**Holiday Inn Express Hotel Bicester Gateway
Business Park Wendlebury Road Chesterton
OX25 2BX**

19/00248/DISC

Proposal: Discharge conditions 2, 4 and 12 17/02557/REM

DRAWING NO.
DD - BIC-NOR-ZZ-DR-EL-A-5001

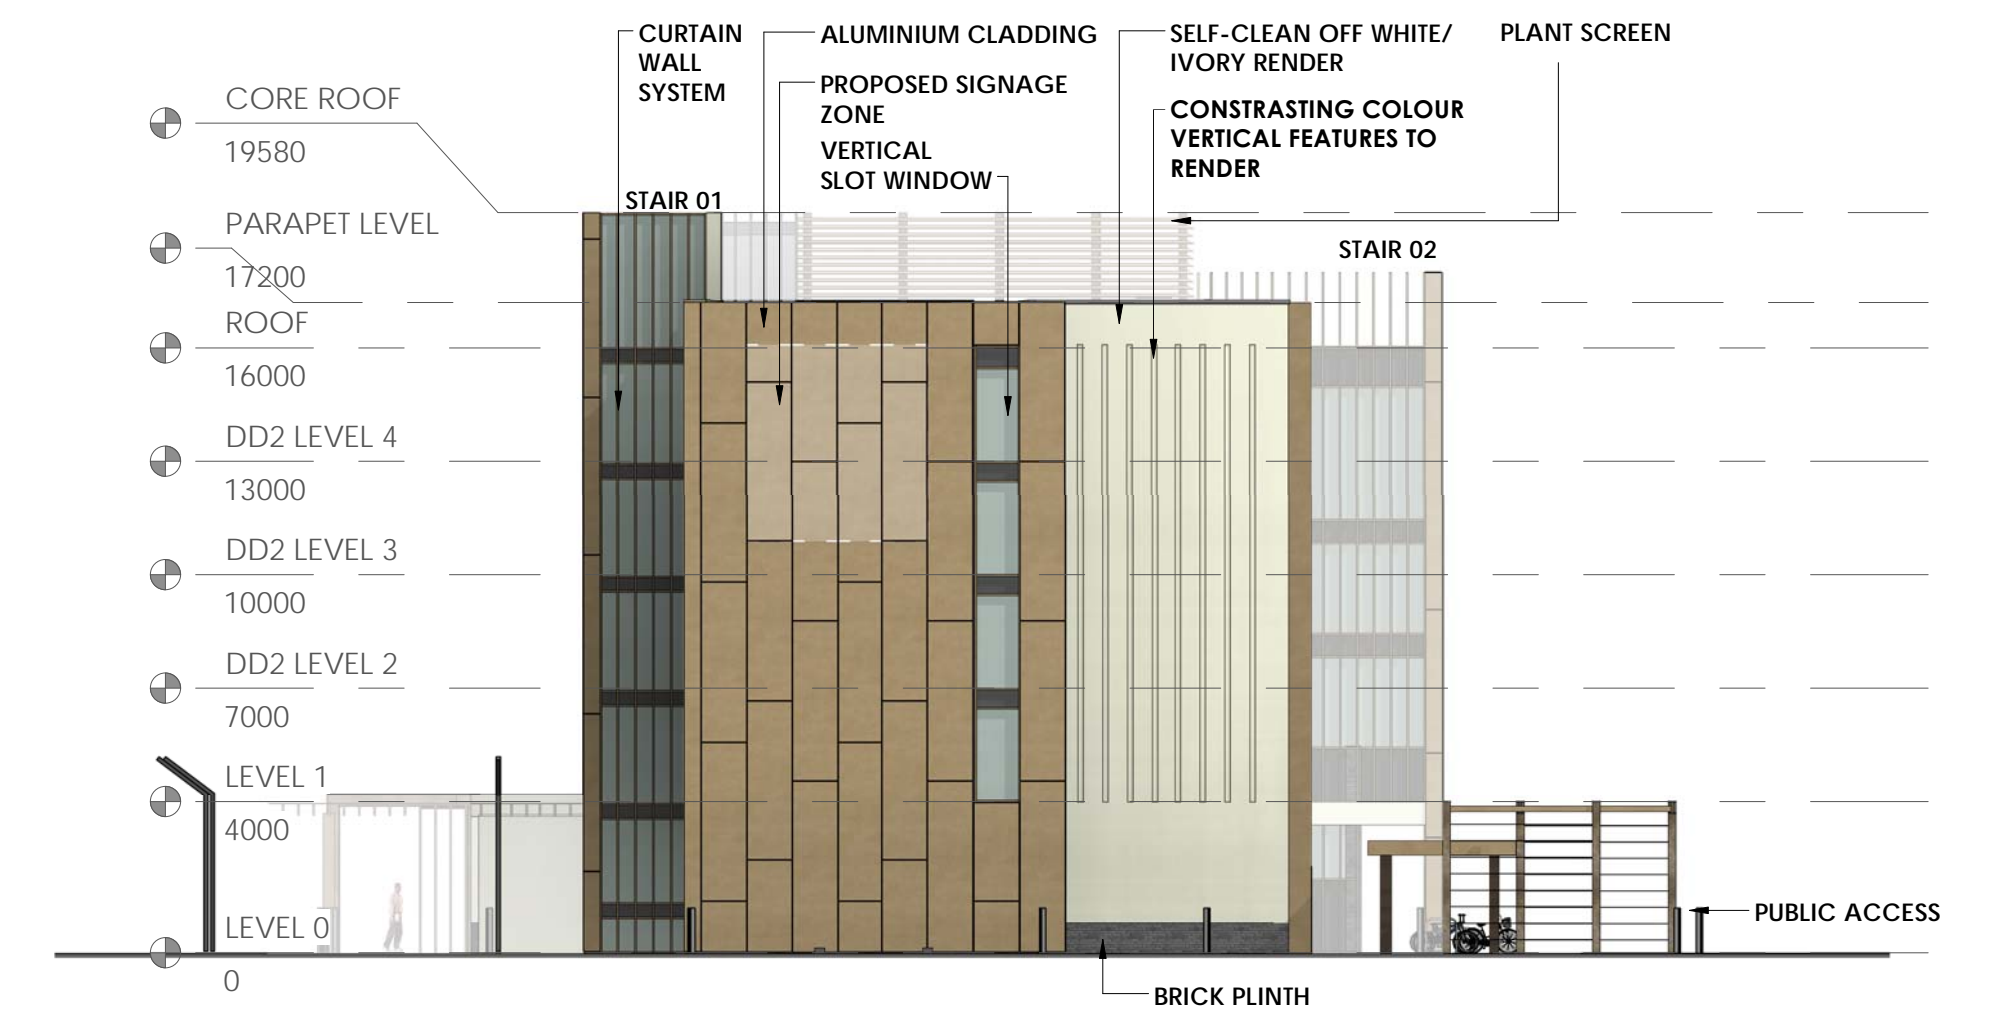
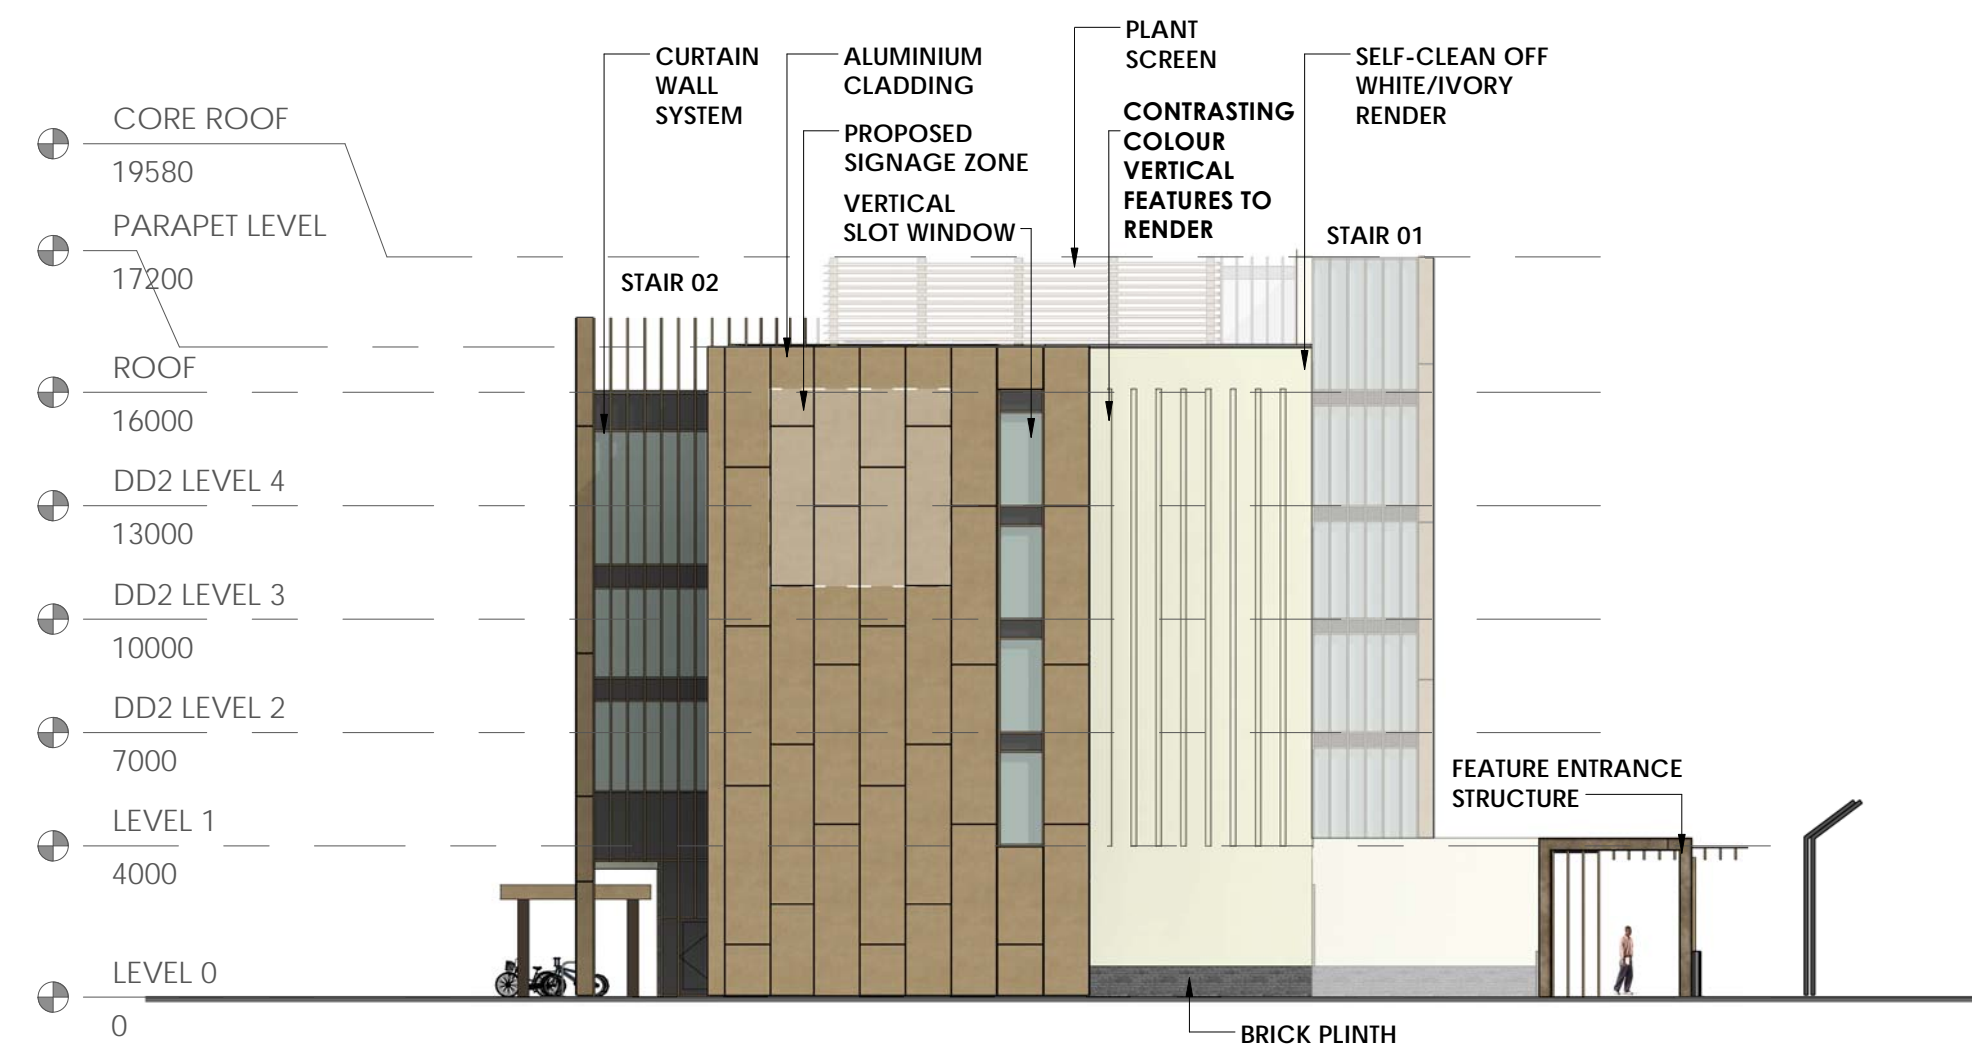
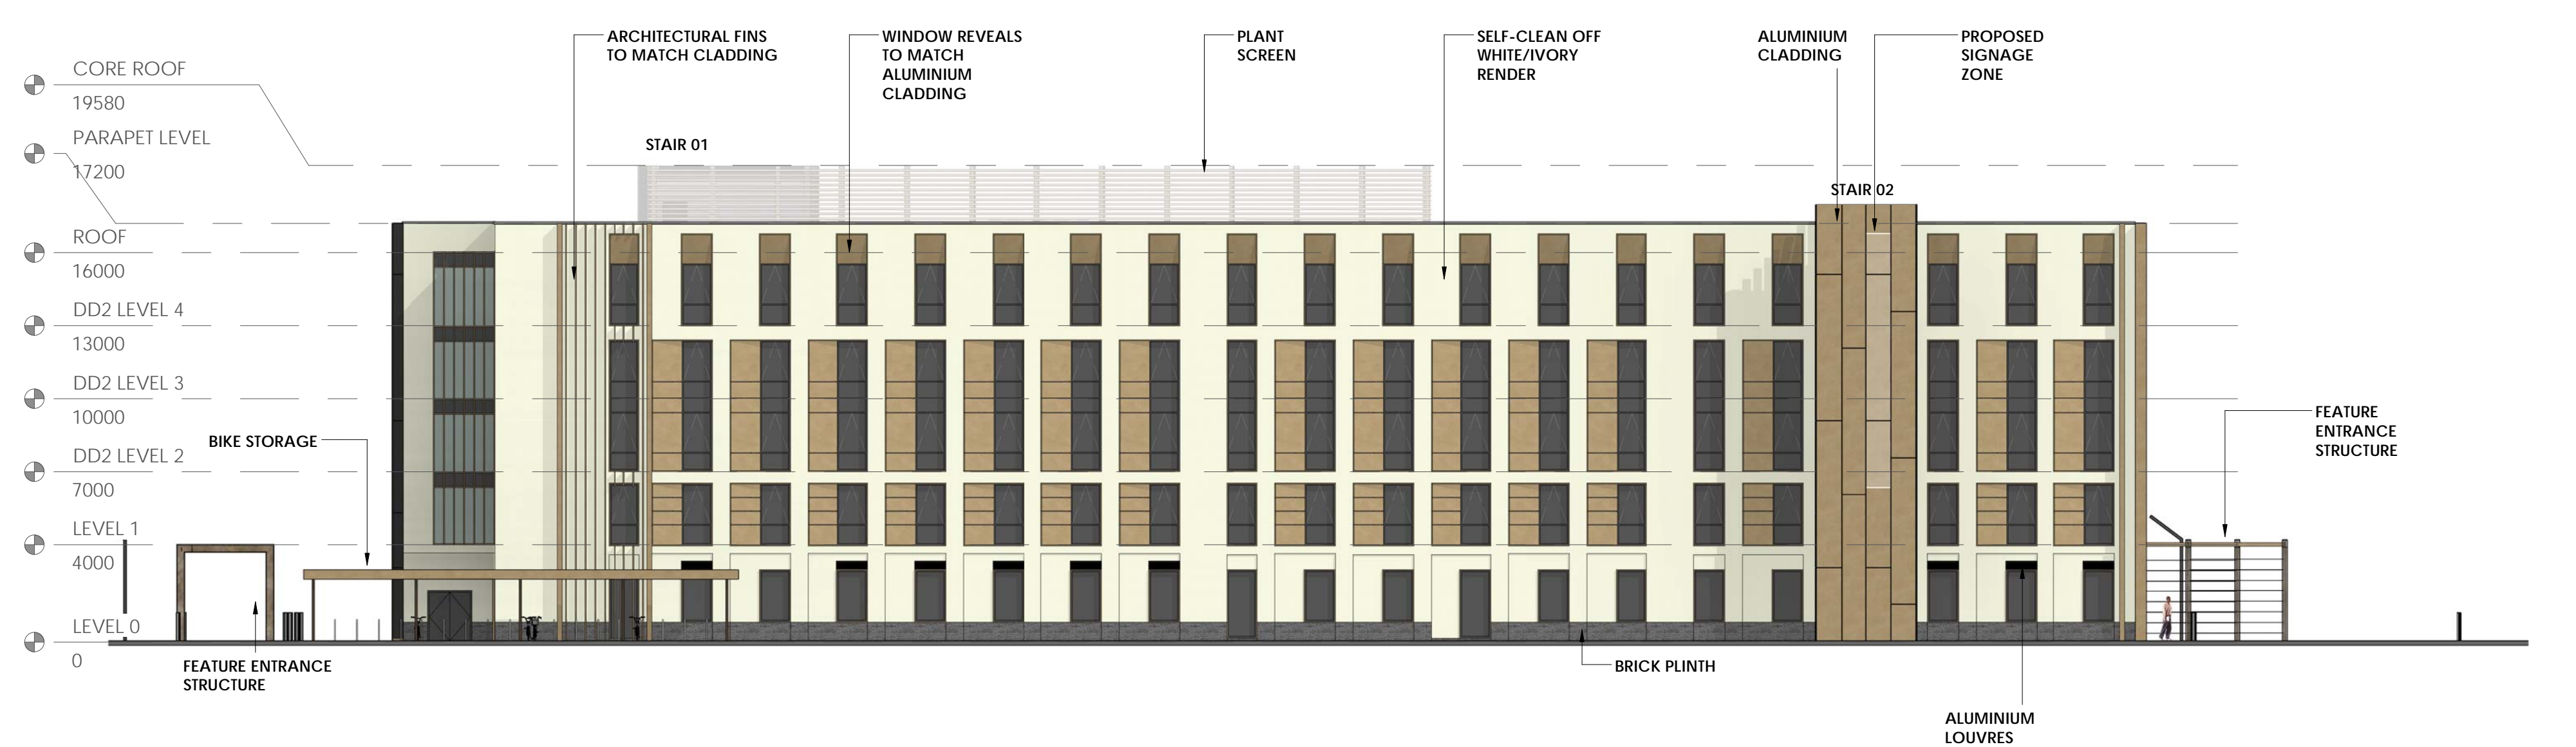
5.2 A schedule of materials and information about the colours and types was submitted. Initially some concern was expressed regarding the proposed cladding colour (a gold colour was identified and I had some concern about what this would look like based upon the image available online). In response, samples were made available of both the cladding and also a brick sample panel of the Ibstock Atlas Smooth Blue and other samples of the ivory cladding, the RAL 7012 colour used for windows/ doors/ plant screen and the grey blocks for the car park. The materials palette is considered to be acceptable now that samples have been seen. The brick and cladding materials are considered appropriate. The gold cladding is a suitable tone of gold that is not garish and I consider it will sit appropriately on this building which is one of the first buildings seen when entering Bicester from the south, which will be a landmark and which does not have a particular context to relate to therefore can make a statement. All other materials described within the register, of which samples have now been seen are considered acceptable and planning condition 2 can therefore be discharged.

The details of the materials as set out in the submitted Materials Register (apart from item 13.0 which, for the avoidance of doubt is not approved), the Sto brochure relating to the external wall insulation, details of the Ibstock Atlas Smooth Blue brick, drawing numbers DD-BIC-NOR-ZZ-DR-EL-A—5001 Rev C (GA Elevations) (for the purpose of demonstrating material distribution only), DE-A-6019 Rev T3 (Rooftop Plant Louvre – Screening detail), DE-A-6803 Rev T3 (Cycle Store Details), DE-A-6806 Rev T3 (Entrance Feature Structure Details) and the samples seen on site on the 04/09/2019. The development must be carried out in accordance with the samples approved.

Scale at A3: 1:800	Project No: A103271-1	Drawing No: Figure 3	Revision: B
Drawn by: Maddie Errington		Drawn date: 01/07/2019	Approved by: Elizabeth Sanders

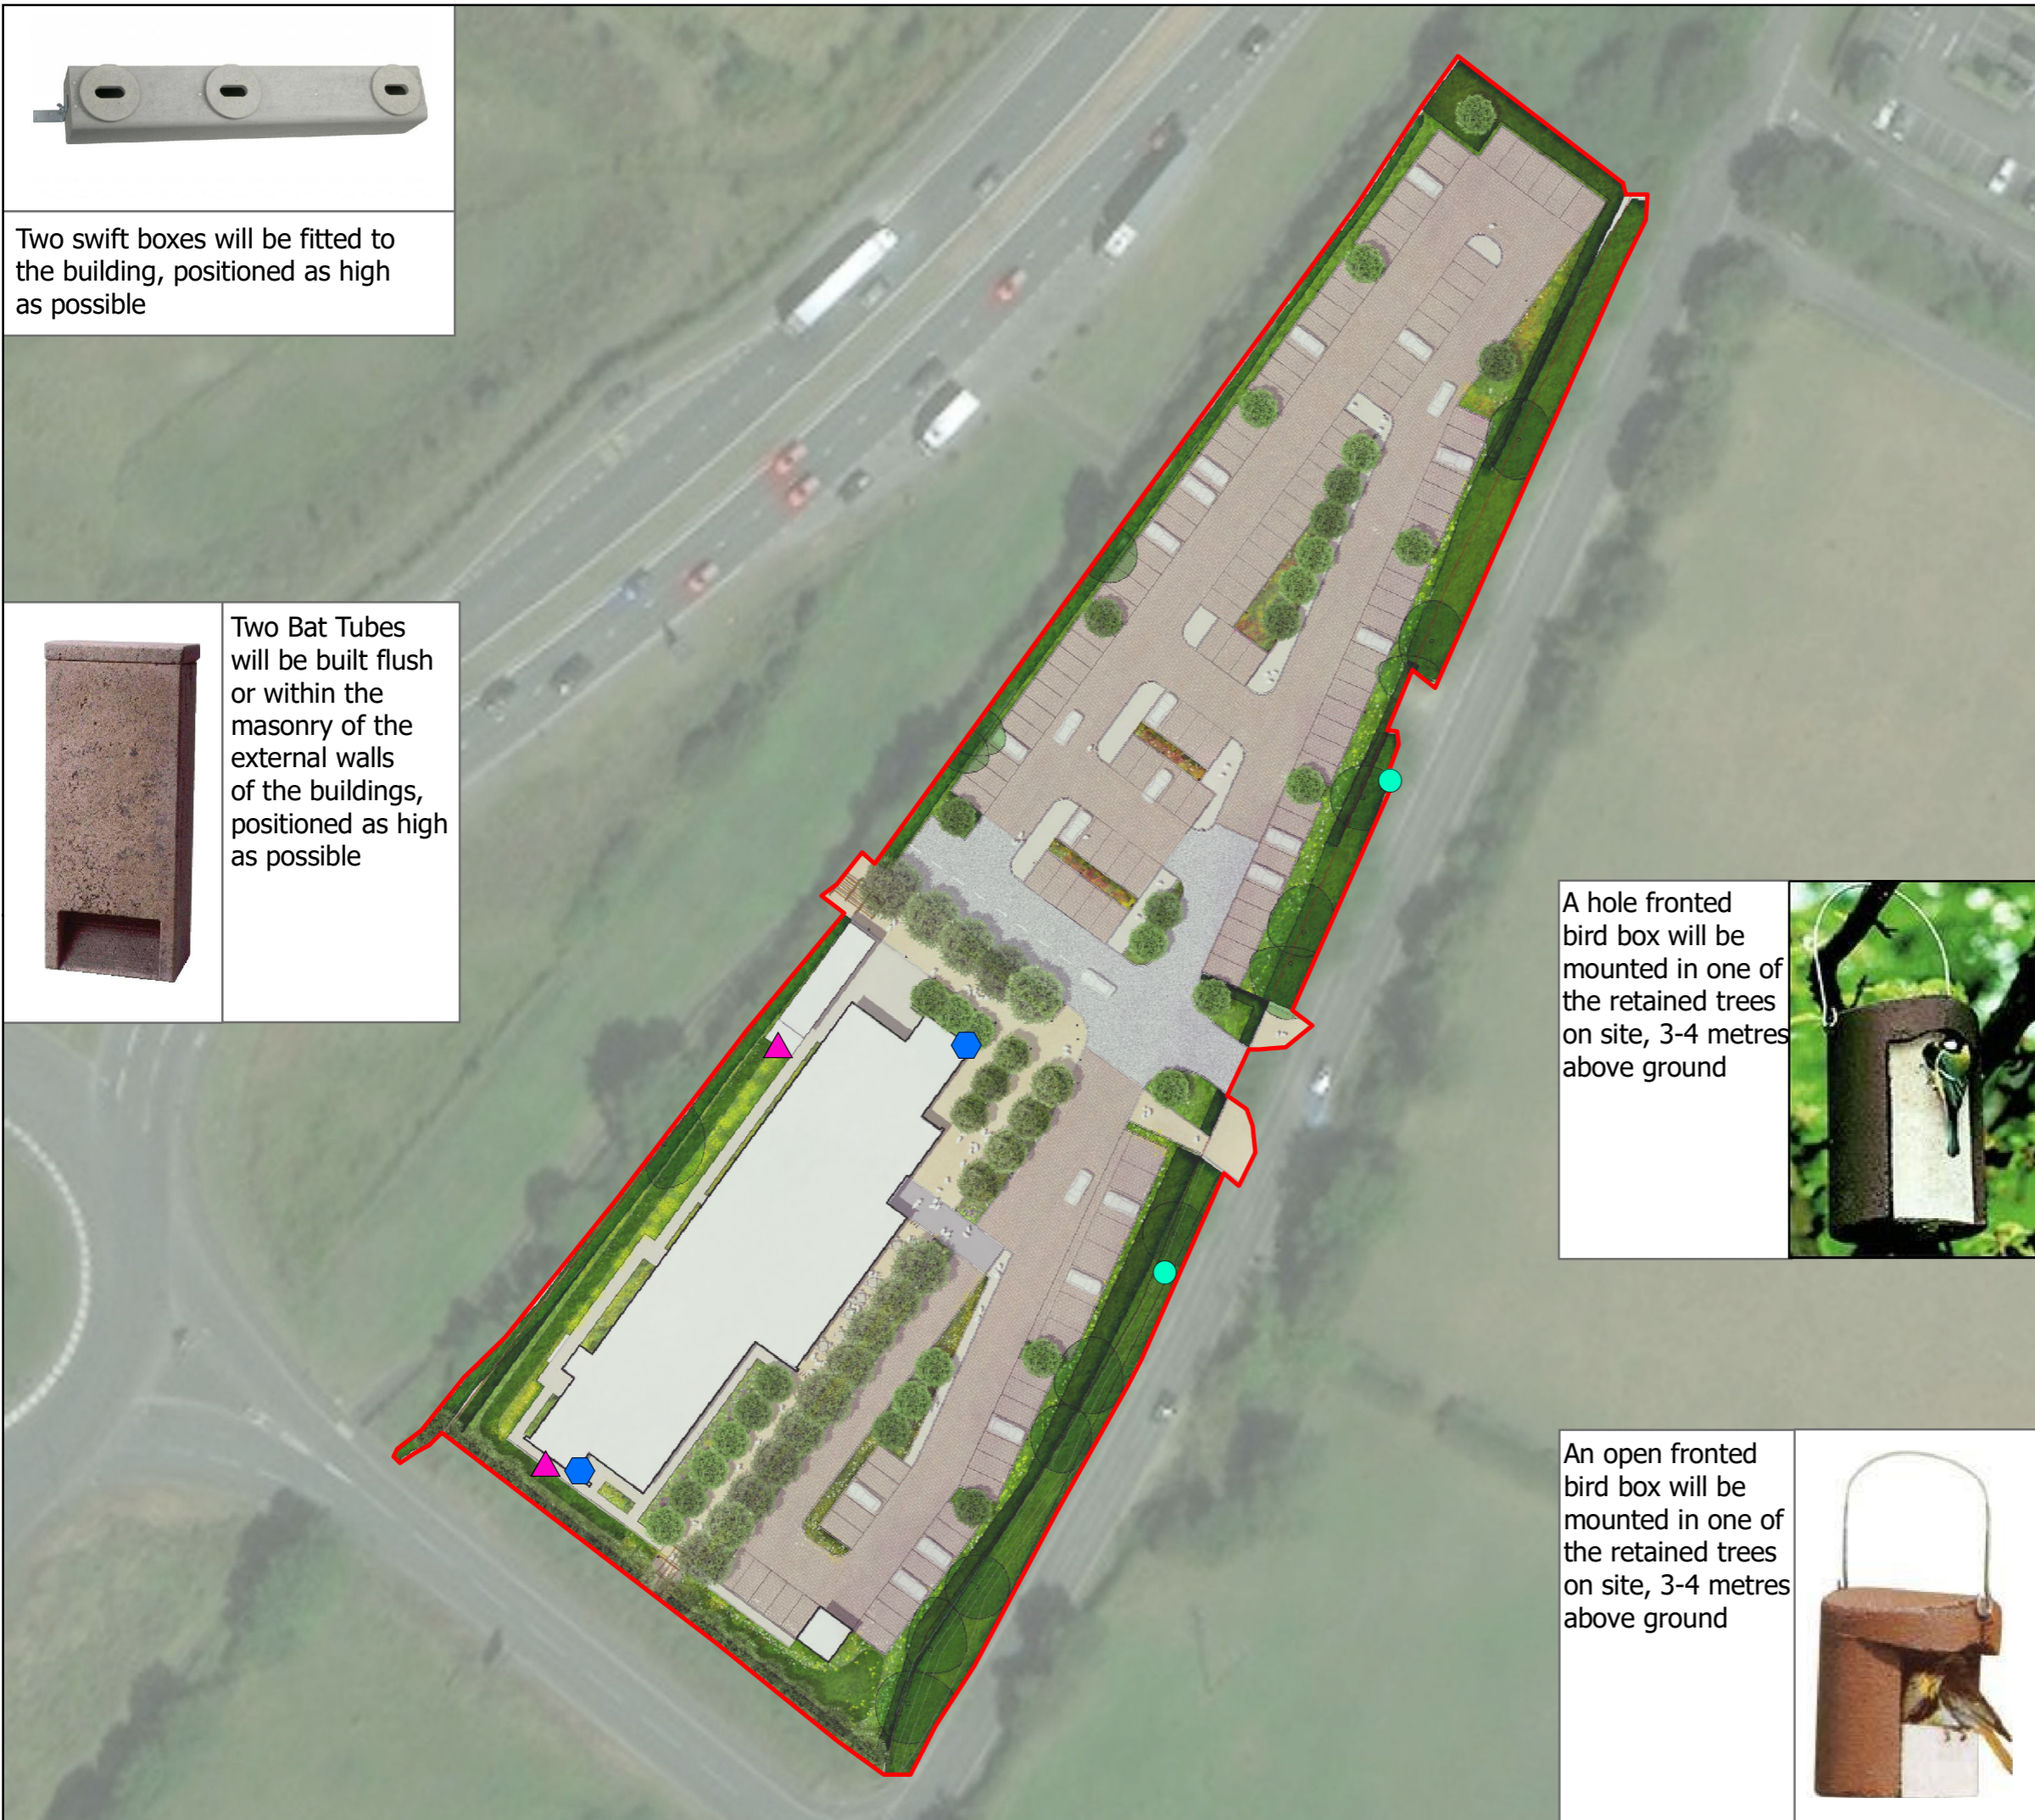
- 4.2 CDC ECOLOGY: No major issues with the Habitat Management Plan. It is suggested that the Southern Aspect triple swift box should be moved to a slightly different aspect (any with relatively clear flight lines) as southern facing boxes are not ideal as they can get too hot. If this is amended, then conditions 4 and 12 could be discharged on the basis of this document.

The details of the Biodiversity Enhancement Measures as detailed within the Habitat and Landscape Management Plan (2019 – 5 years post-development) prepared by WYG dated 25 June 2019, amended version received in the department on the 05 September 2019 and the details shown on drawing numbers Figure 3 Rev B (Biodiversity Enhancement Scheme), Figure 2 Rev A (Phase 1 Habitat Plan, 001 Rev 1 (Proposed Lighting Layout (3m cycle way)) and 001 Rev 2 (Proposed Lighting Layout). The biodiversity measures shall be installed as part of the development.
